From: [Michele Lorilla](#)
To: [Kevin Nguyen](#); [Molly McGuire](#); [Ryan Harriman](#); [Gareth Reece](#)
Subject: RE: Strand Residence (Permit #2207-019) SUB2 Review Comments
Date: Thursday, April 6, 2023 8:10:09 AM

Project: Strand Residence
Location: 6950 SE Maker St
Mercer Island, WA 98040
Permit Application Number: 2207-019

Commenting Review Discipline: Civil Engineering

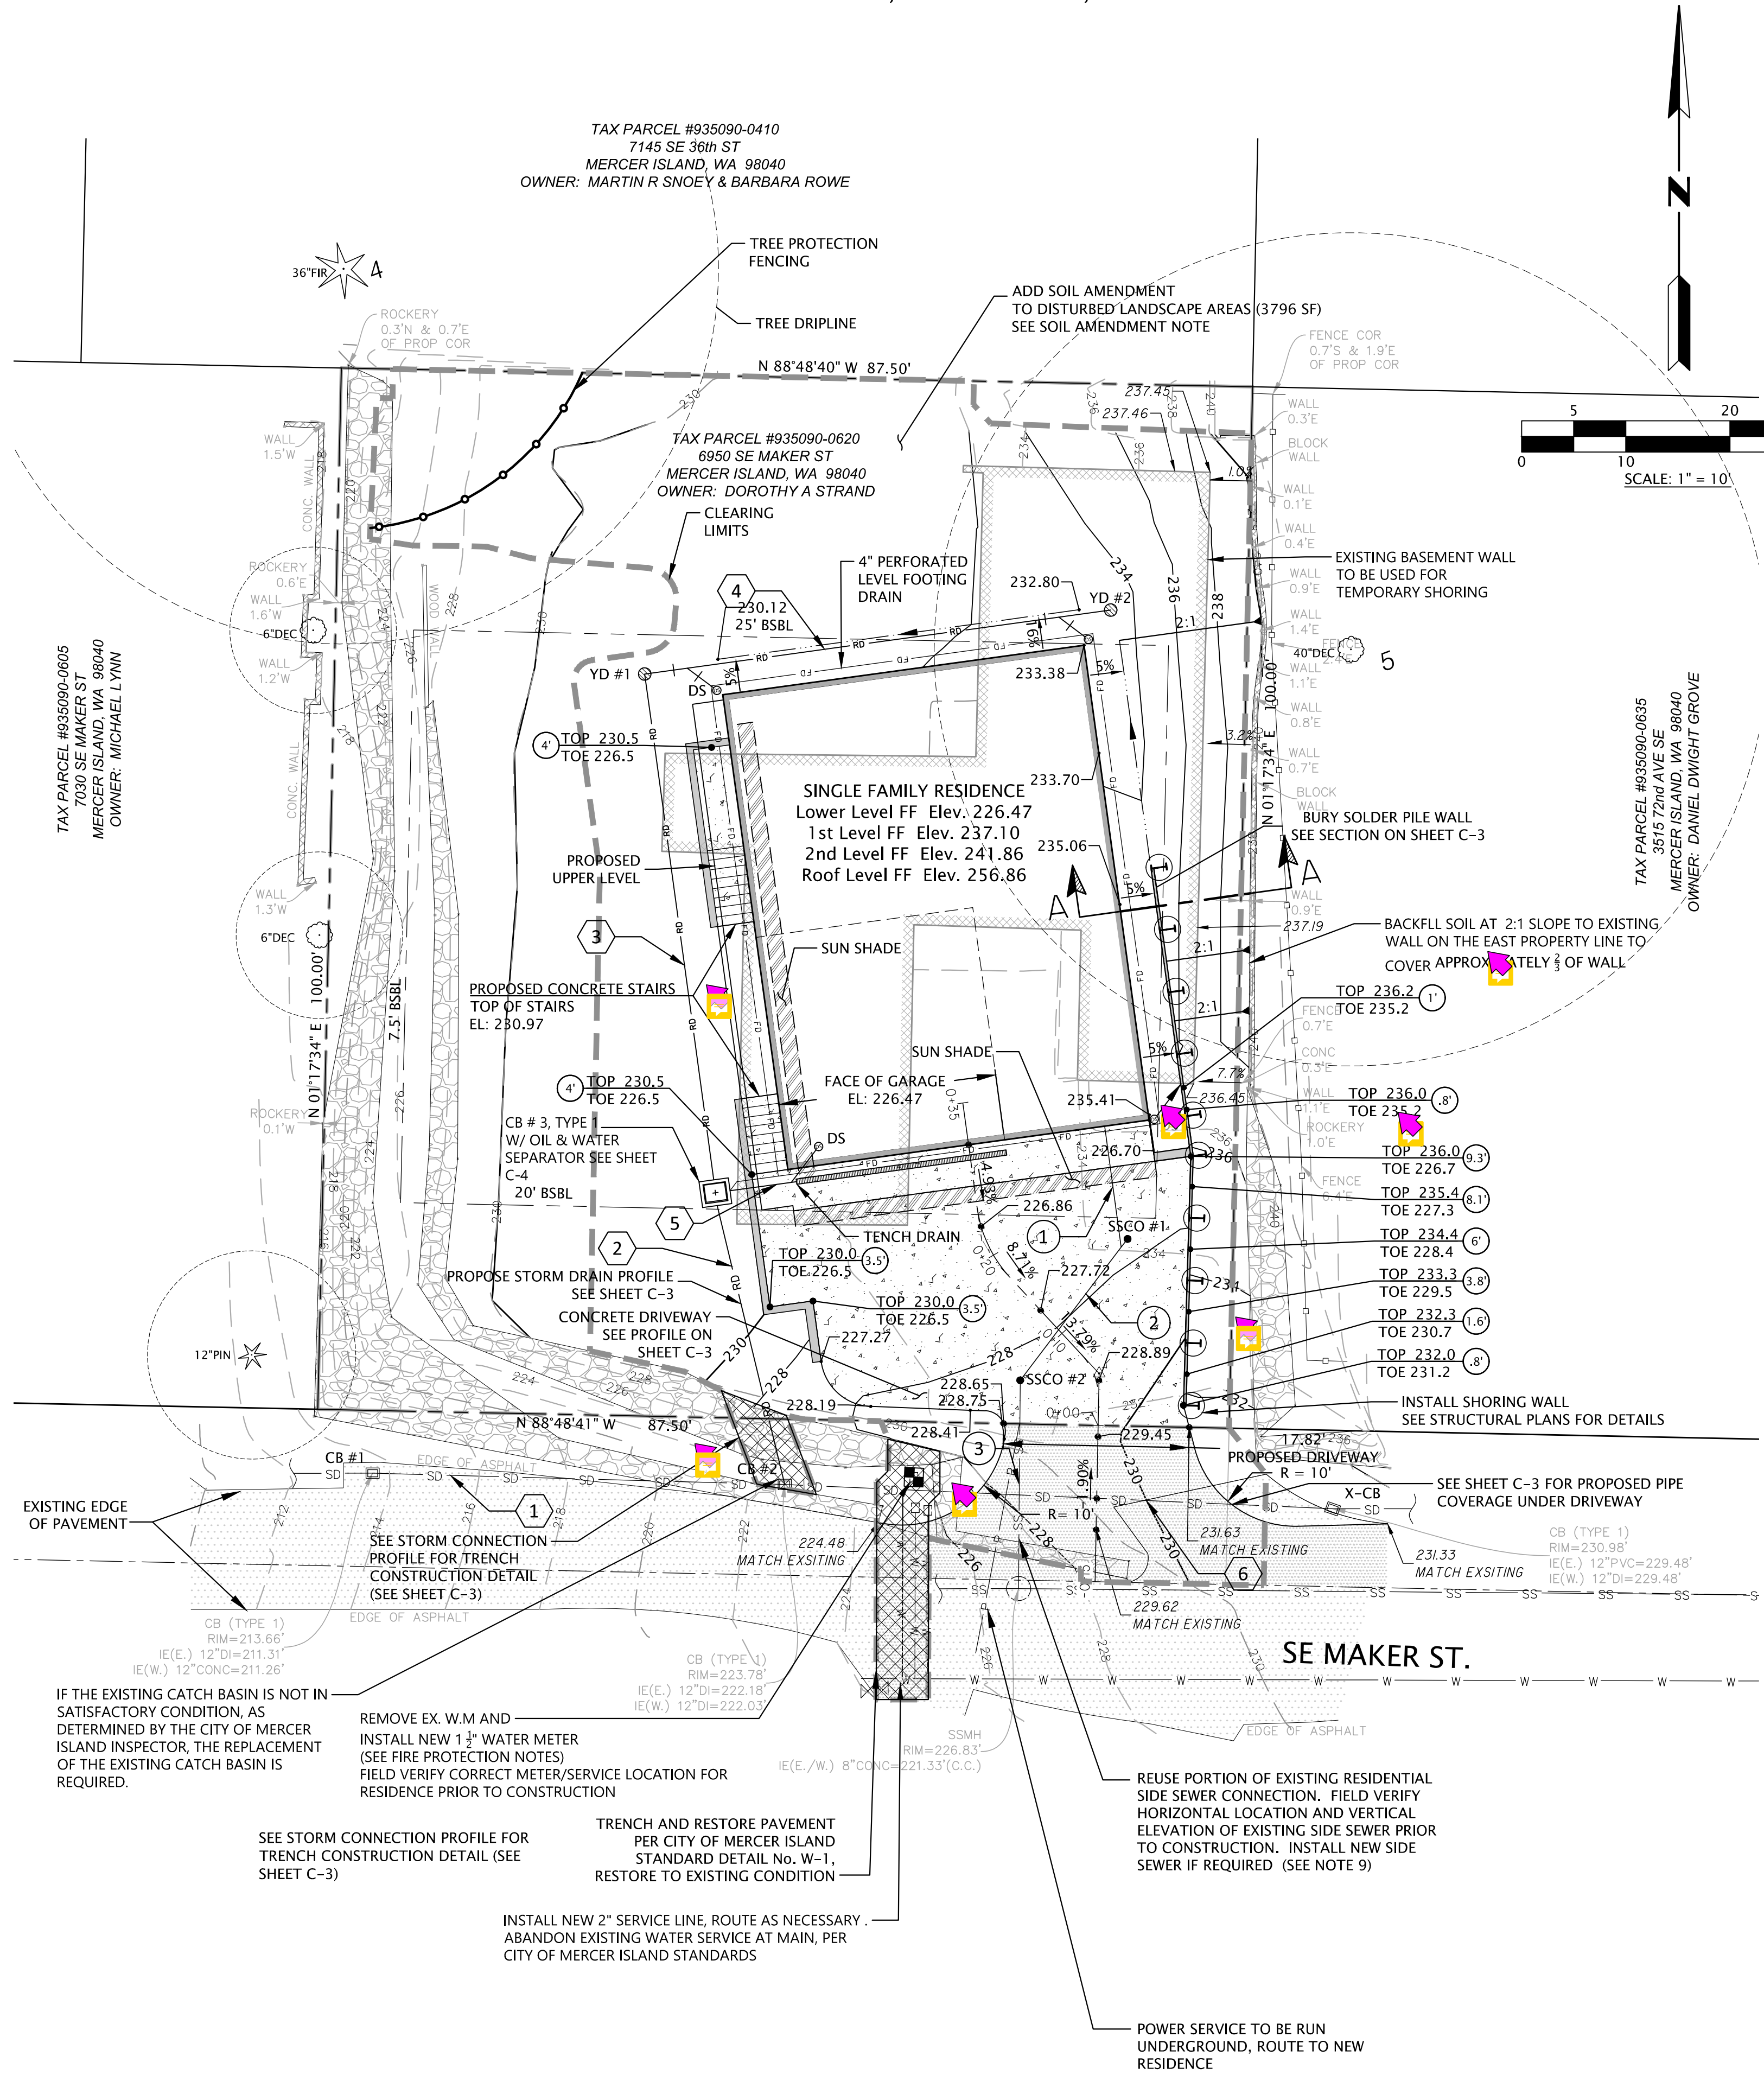
I would like to inform you that I published a new comment for civil C-2 in addition to the comments I uploaded on March 6th.

The existing rockery/retaining wall encroaches into City ROW and is on top of City storm and water. The rockery/wall within the western/eastern property boundaries shall be removed/replaced away from City ROW, and a complete design shall be provided to support this area.
